RE: SSD 15_7033 – Site 53 | 2 Figtree Drive, Sydney Olympic Park

I refer to the Environmental Impact Assessment for the above SSD Application, which was referred to Sydney Olympic Park Authority (the Authority/SOPA) for comment on 15 October 2015. The following comments are based on the information provided. Some concerns may be resolved through further information being provided by the applicant.

SK02 - SOPA markup

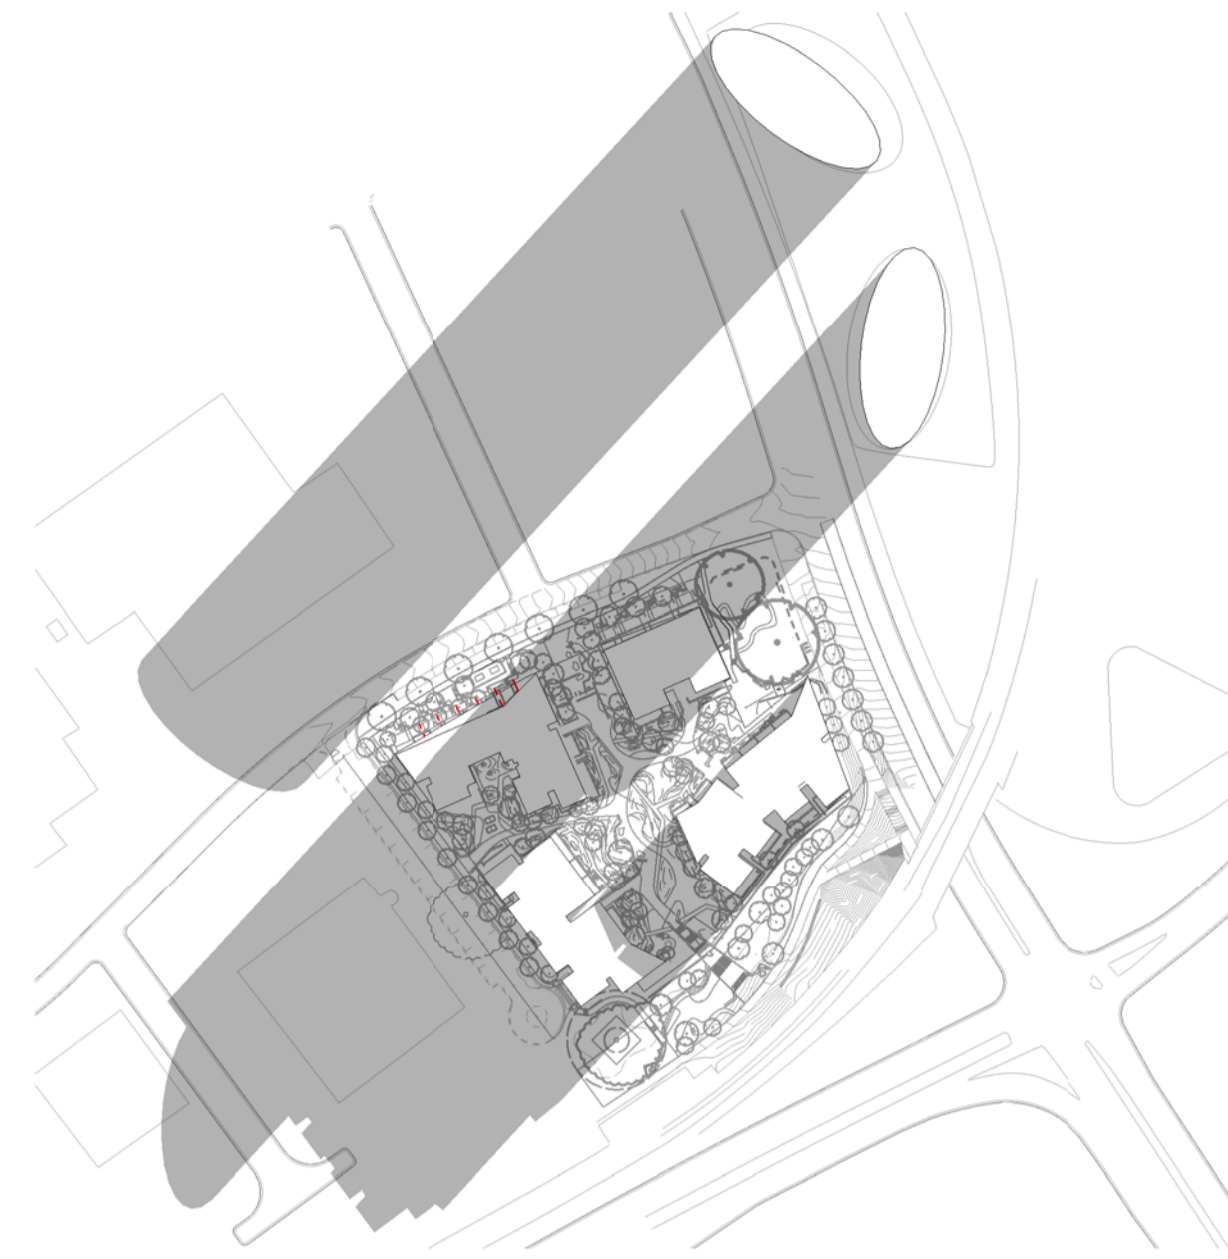
The building footprint does not extend to the master plan boundary on Australia Avenue, resulting in a heavily landscaped setback that gives a very suburban feel to this major frontage at the entry to the town centre. It is recommended that the ground level retail area be extended to the street boundary as shown in attached marked up sketches (SK01 and SK02). The use of brickwork for this frontage is supported.

AHD										MGA										1:250										AT										A1 SEE										S14184										C-0100										B

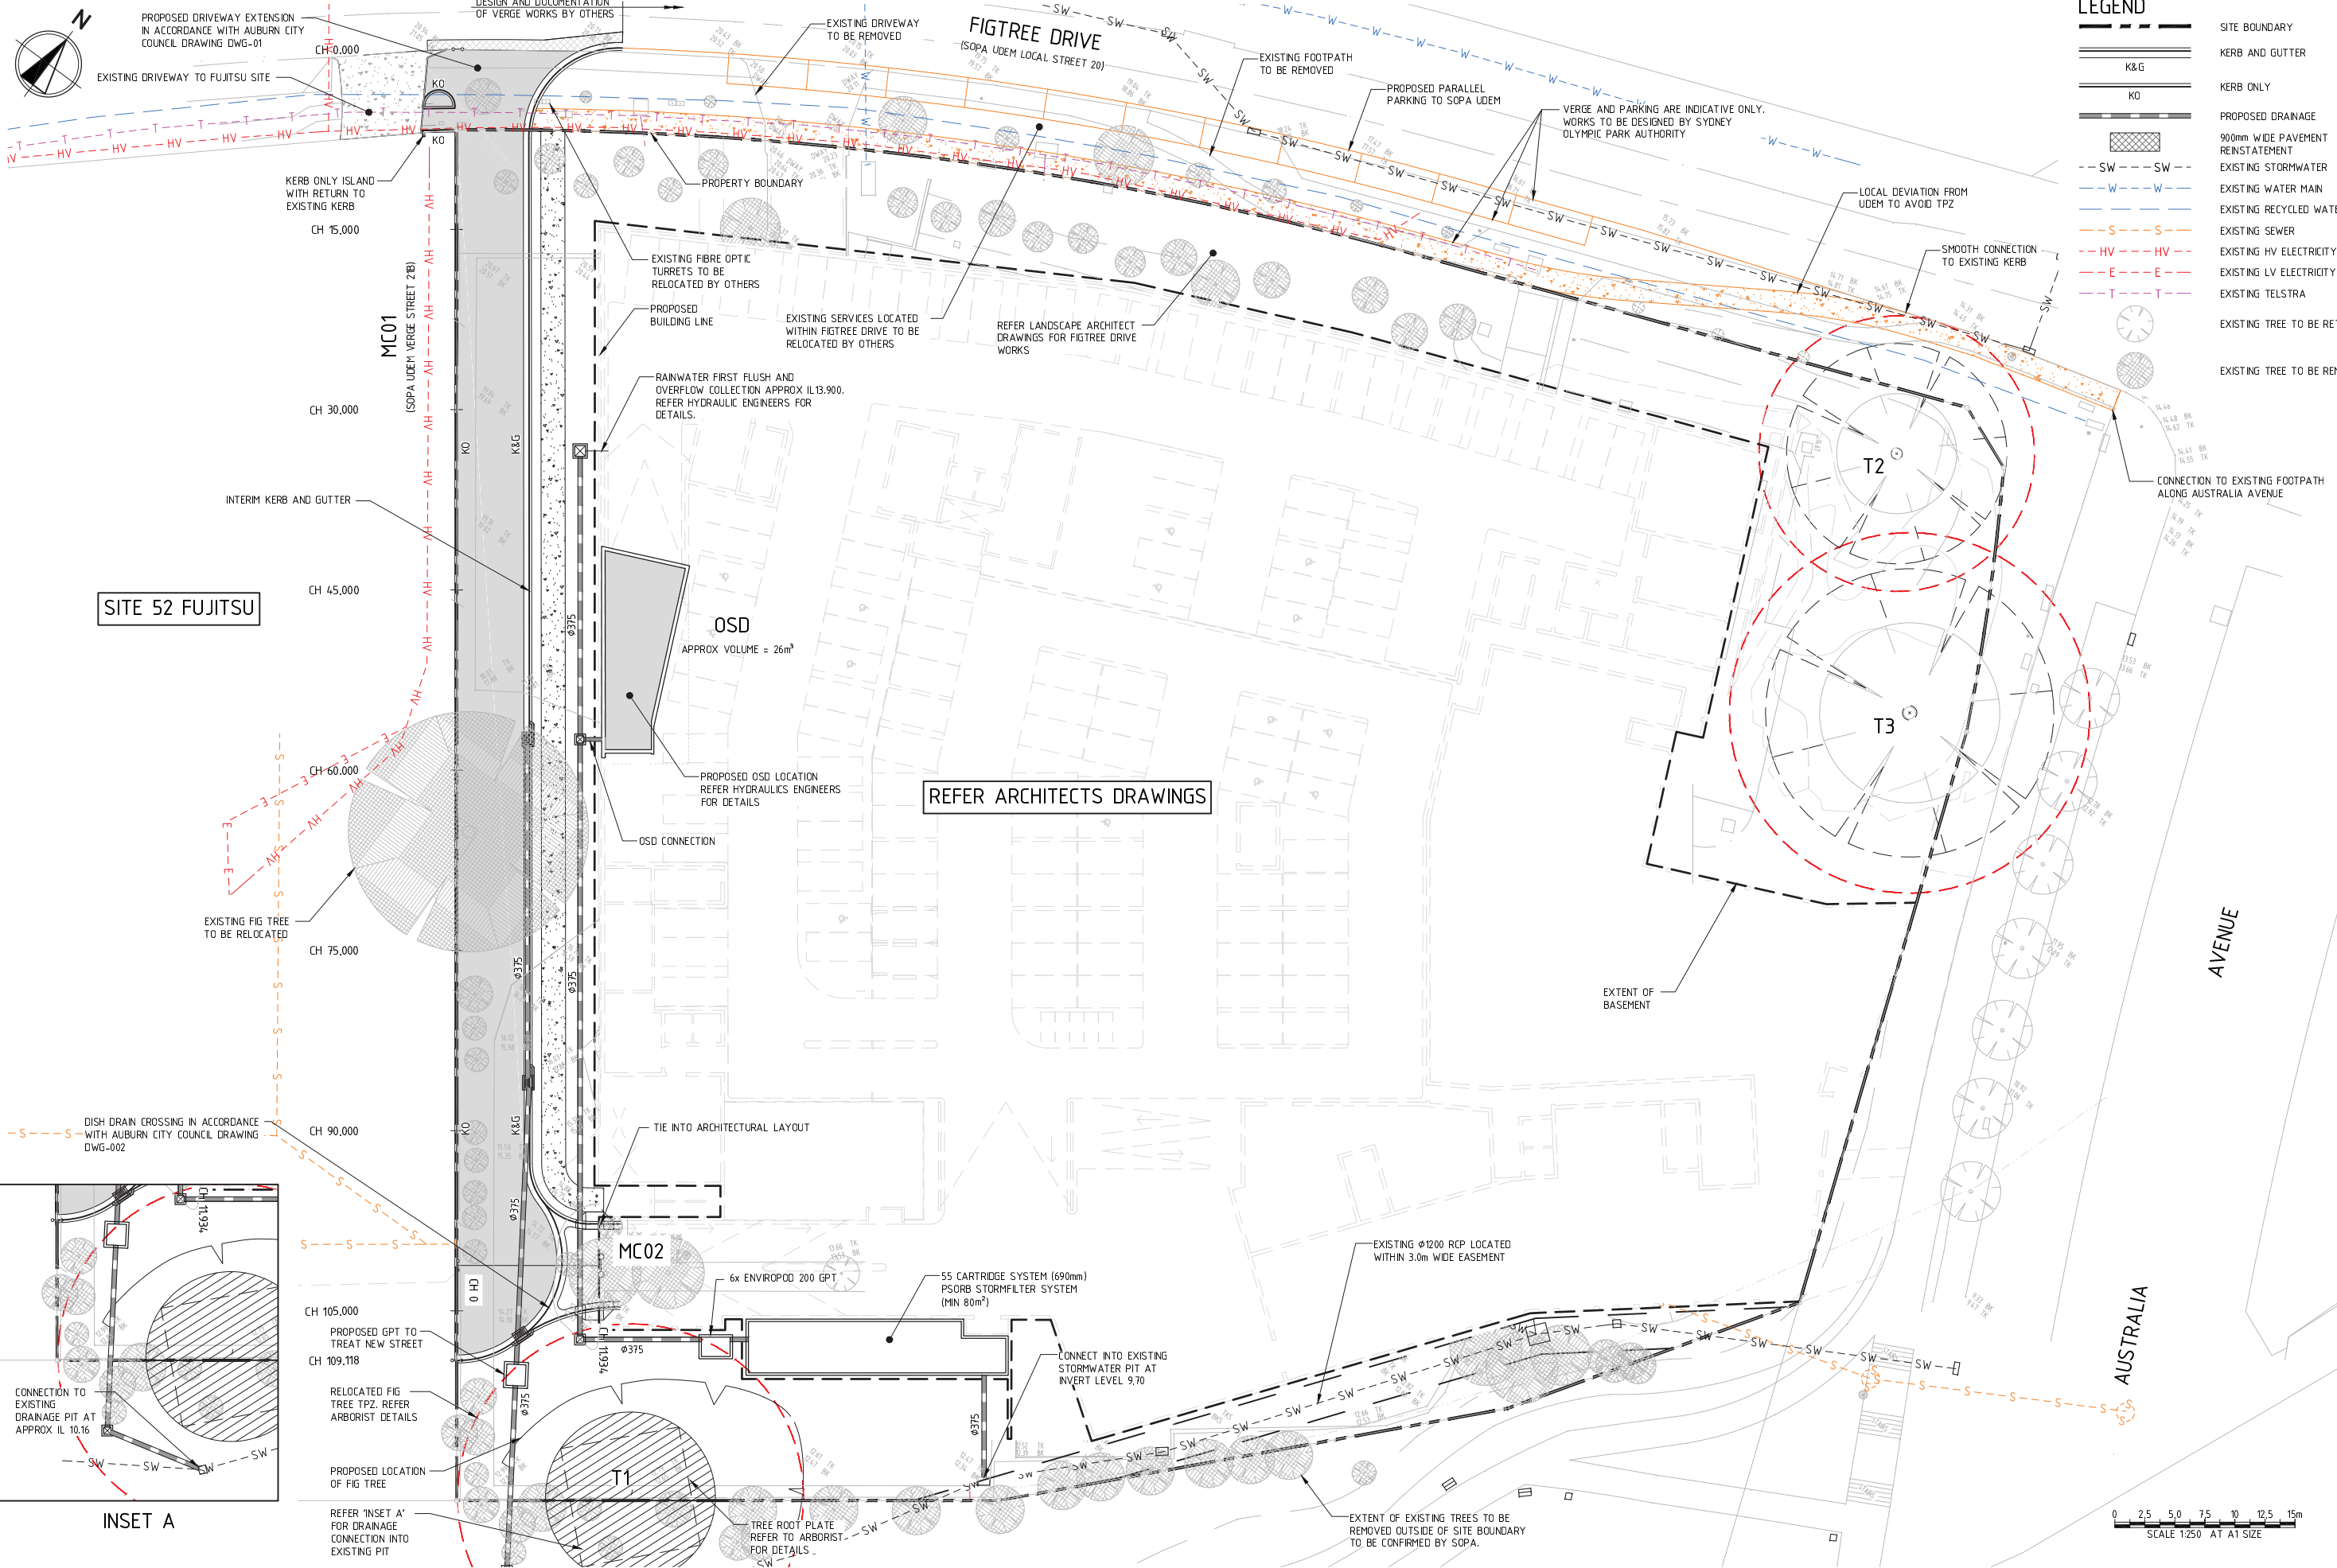
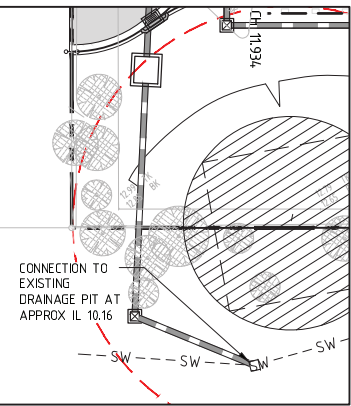
Civil Siteworks Plan BG&E C-0100B indicates extent of basement excavation in close proximity to root plates and canopy of existing figs. It is recommended that the Arborist Report should nominate the extent of fenced enclosure for 'Tree Protection Zone' during construction works.
